CITY OF ALBUQUERQUE

PLANNING DEPARTMENT – Development Review Services

RE: American Toyota (File: C18D012)
Drainage Report, Engineer's Stamp Date 3-16-15
Grading and Drainage Plan, Engineer's Stamp Date 3-17-15

ENGINEER'S SEAL  3/27/15 DAVID SOULE P.E. #14522	AMERICAN TOYOTA GRADING AND DRAINAGE PLAN  1806 CENTRAL AVENUE SE SUITE 201 ALBUQUERQUE, NM 87106 (505) 872-0999	DRAWN BY WCWJ
		DATE 3-27-15
		21403-LAYOUT-1-25-14
		SHEET #
		JOB # 21403

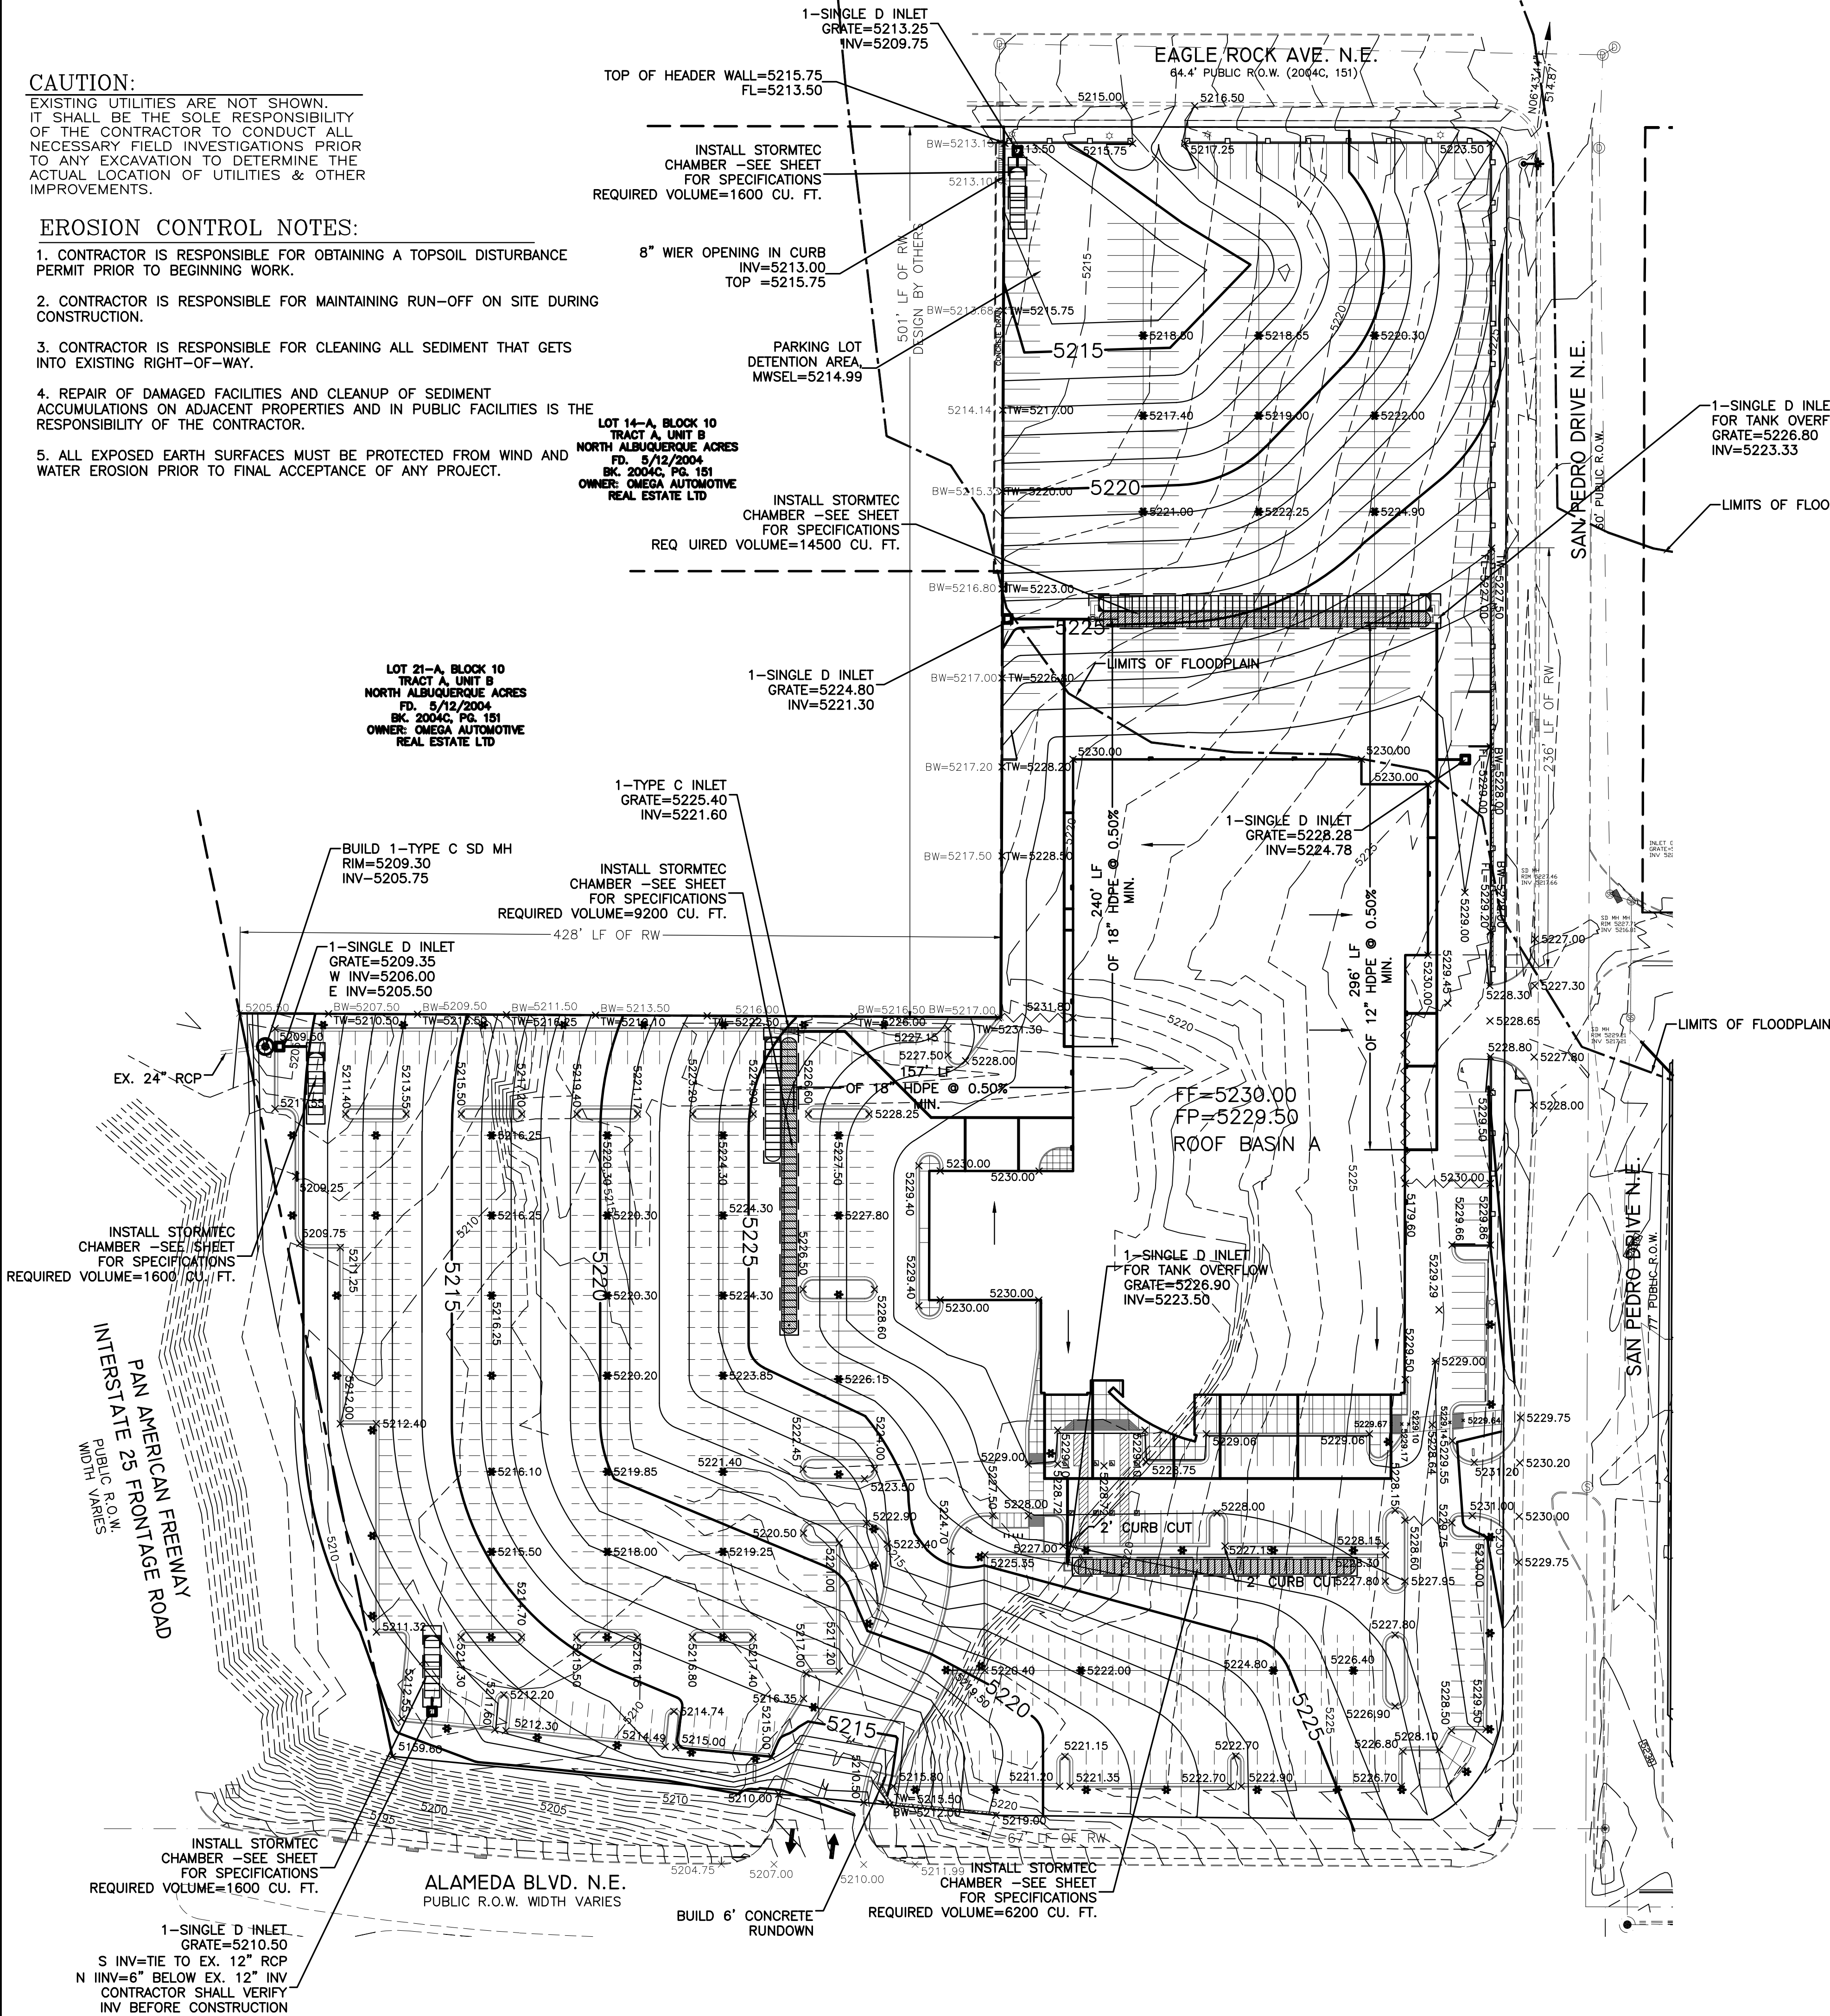
1. The proposed runoff to the Alameda Storm Drain is limited to 25 cfs. This is based on trying to reconcile the difference between the existing runoff of 33 cfs and the allowed runoff of 16 cfs from SAD #201(though this site is not a part of the hydrology report).
2. The "first flush" needs to be captured at Outfalls 2,3, and 4.
3. Details showing how the "first flush" mechanism will work need to be shown prior to approval for Building Permit.
